Your ref: 3/2020/0525
Our ref: DC/20/2685
Date: 04-SEP-20

Location: Plane Tree Farm, Chipping Road, Chaigley, BB7 3LT
Proposal: Installation of new feed storage bin

Thank you for forwarding the updated information setting out revised plans for the above application for planning permission which we received on 26 August 2020. United Utilities wishes to make the following comments regarding the updated information.

Title: Site Plan

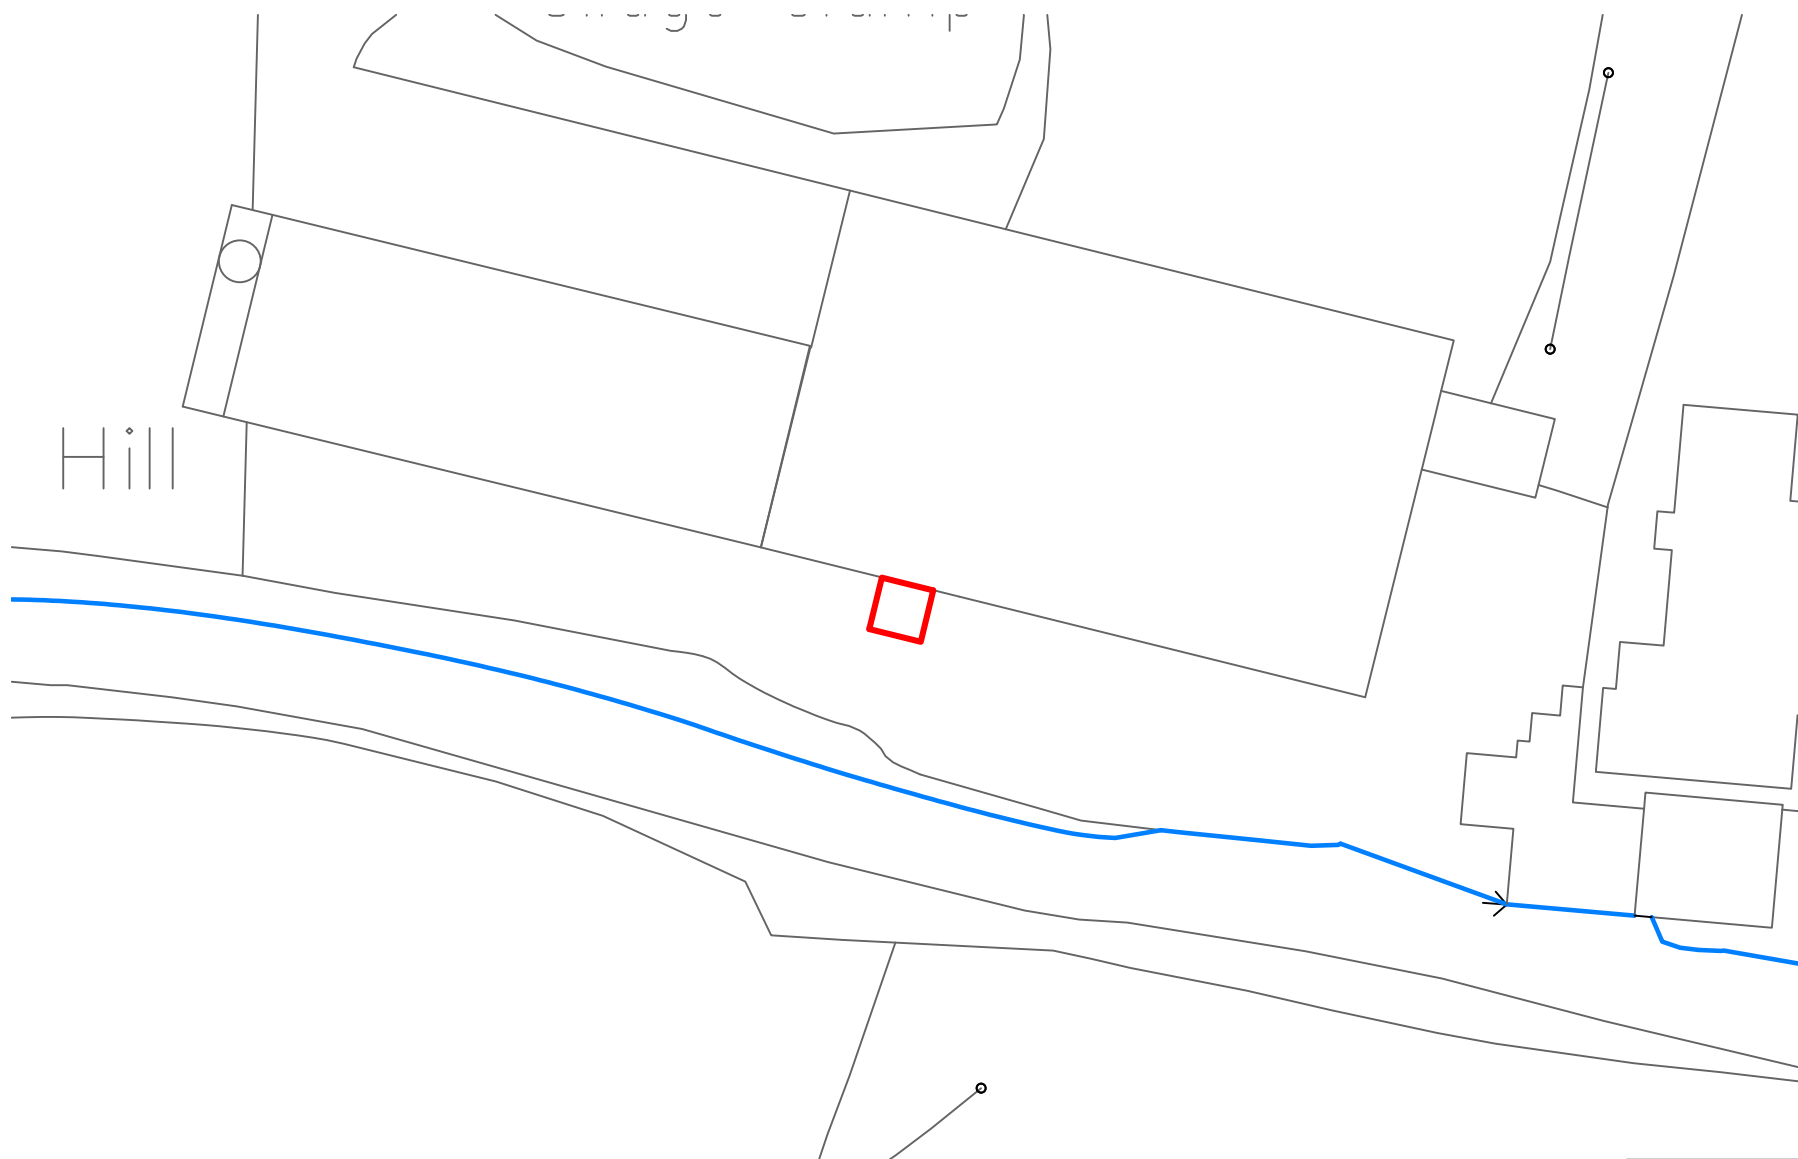
Notwithstanding the amendments to the submitted plans, United Utilities continues to OBJECT to the proposed development.

Whilst the applicant has commenced dialogue with United Utilities regarding the location of the water main, the exact location is still not confirmed. We therefore recommend that the applicant continues dialogue with Sara Livesey in United Utilities Developer Services who can be contacted by email at DeveloperServicesWater@uuplc.co.uk so the precise location of the main on-site can be confirmed and the impact of the proposed development on our asset fully considered prior to determination. We would also wish to agree any approach to construction near our water main.

As previously noted the proposed feed silo continues to appear to be over or in close proximity to our strategic large diameter water main. This is a major pressurized water supply asset and as we need unrestricted access for operating and maintaining it, we will not permit development over or in close proximity to the main. We require an access strip as detailed in our '*Standard Conditions for Works Adjacent to Pipelines*', a copy of which is enclosed.
